PLANNING AMENDMENT

H13/1125/98

Description: Proposed garaging and garden
store inc. vehicular access

Amendment: Revised turning facility within garden
Drawing No. 980502/02A

980502 / 02A

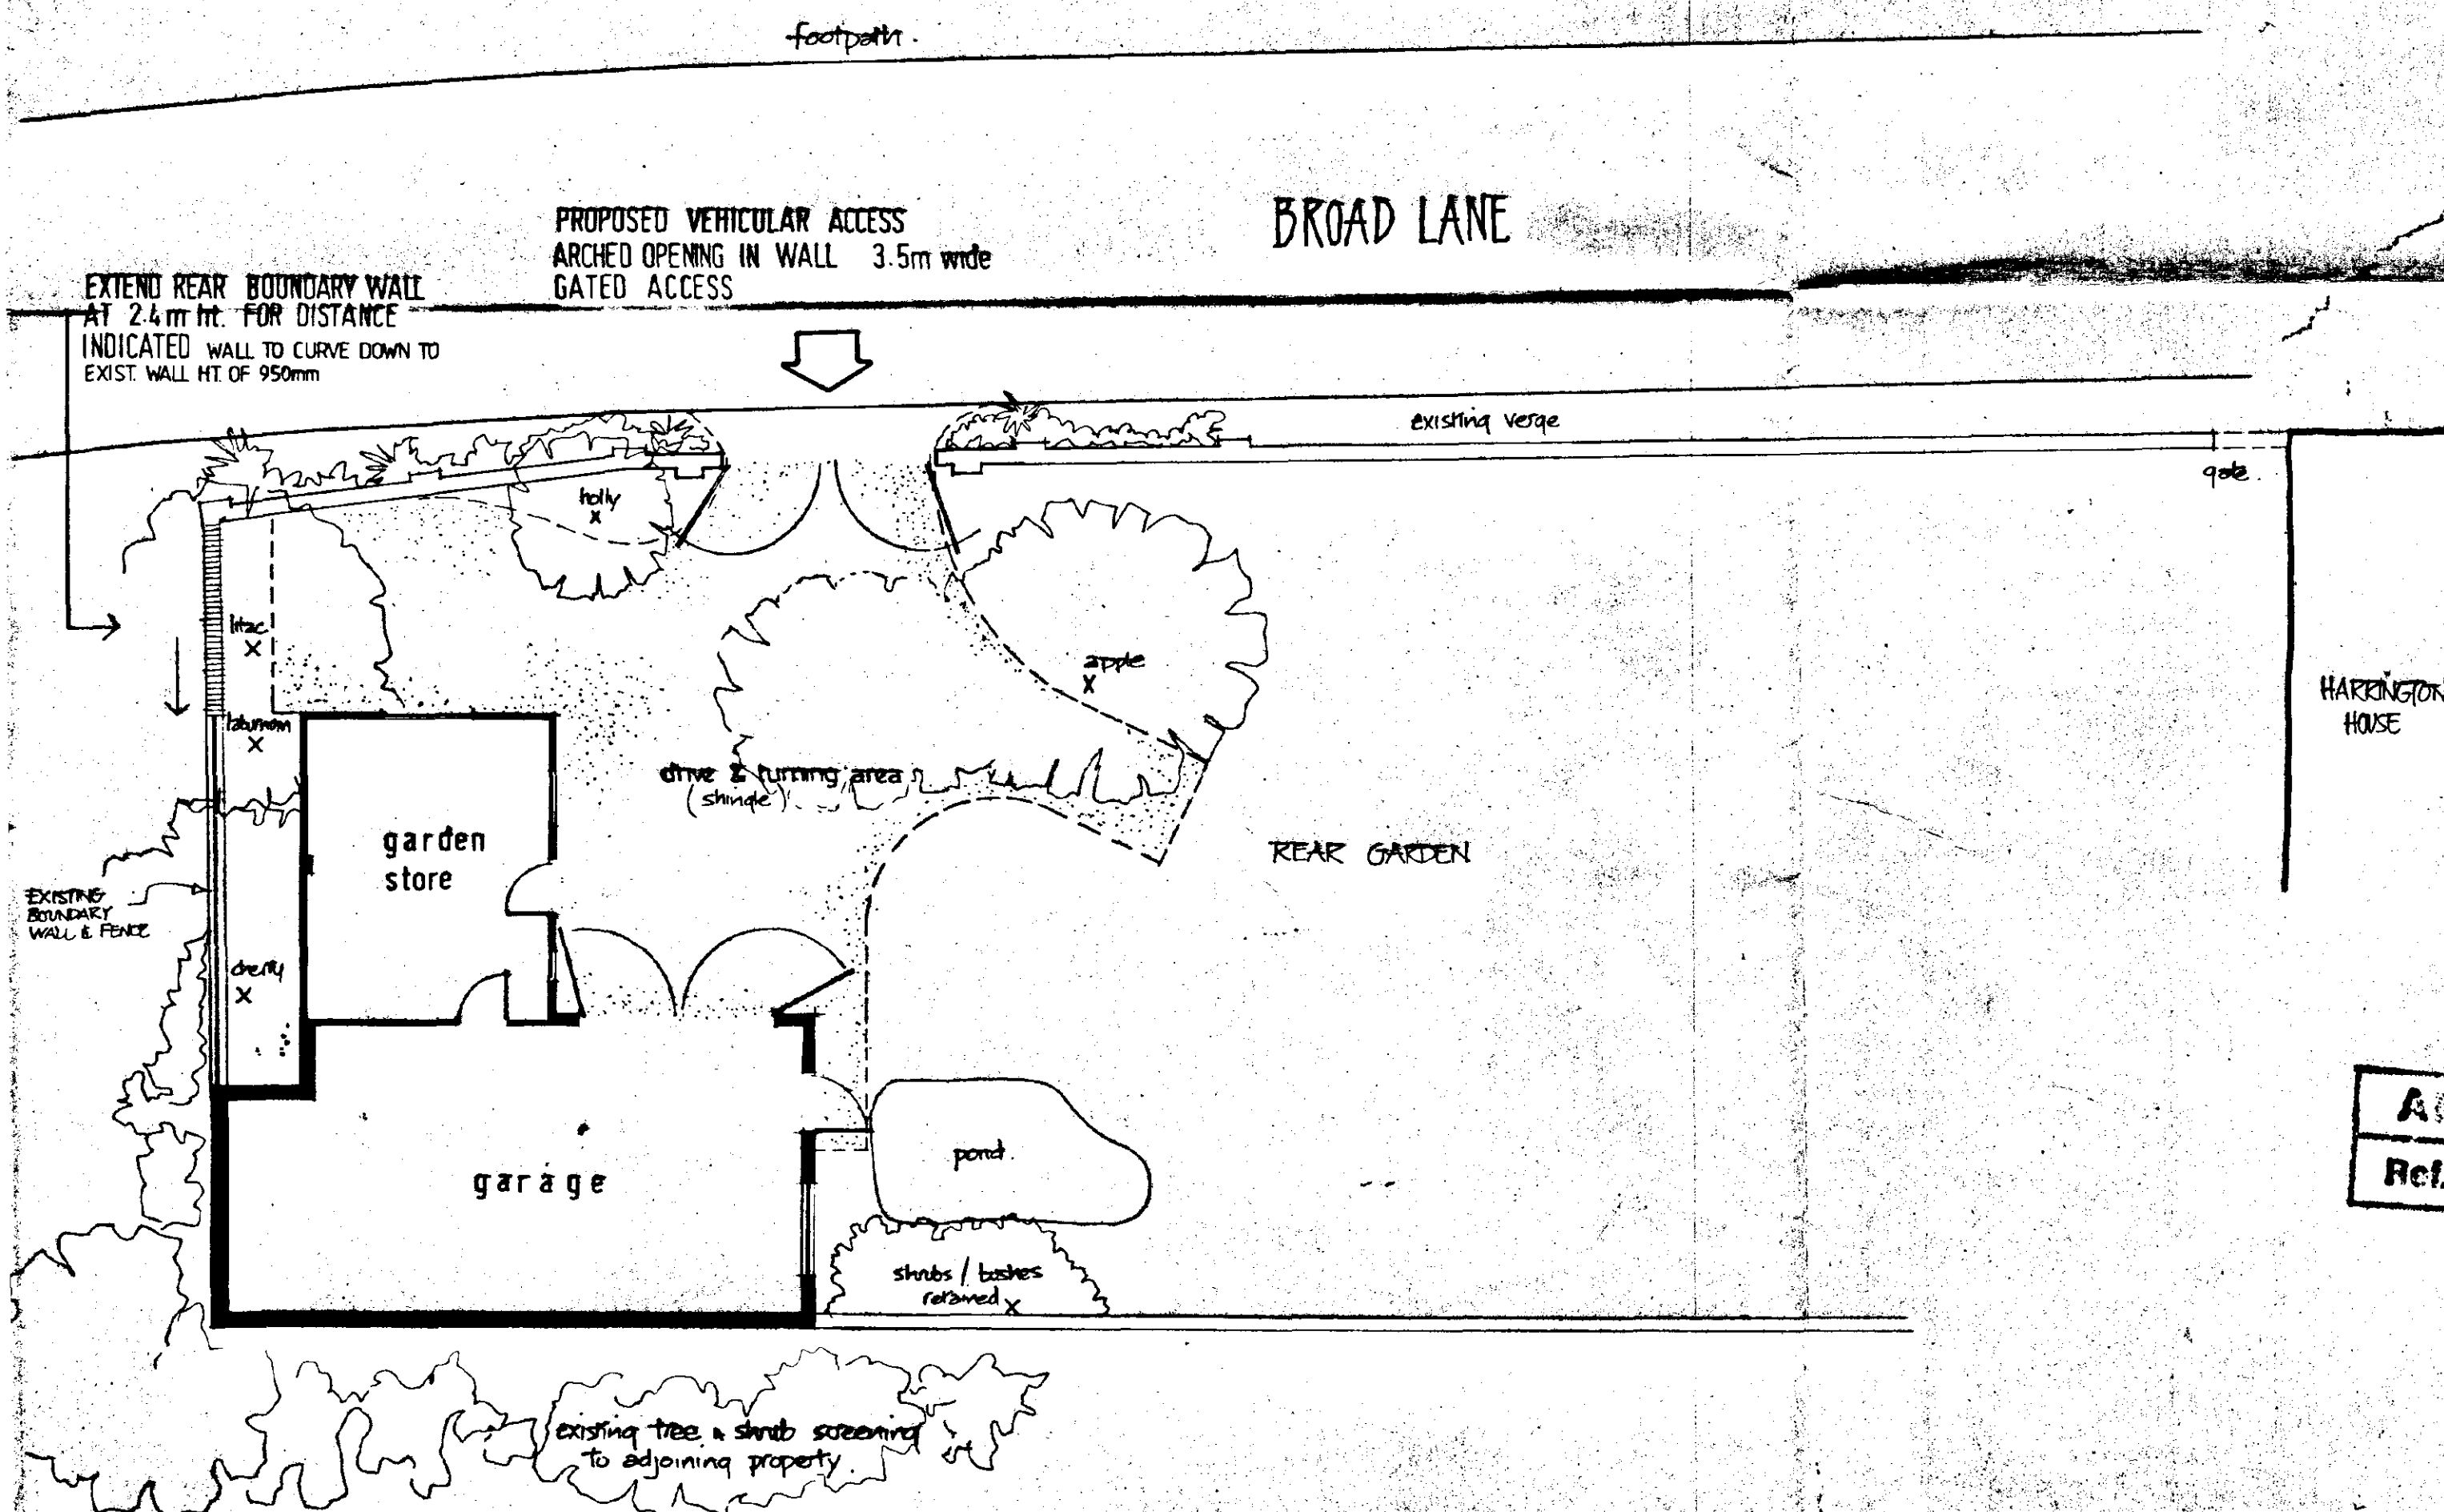
REVISED TURNING FACILITY WITHIN
GARDEN AS REQUESTED BY L.A.
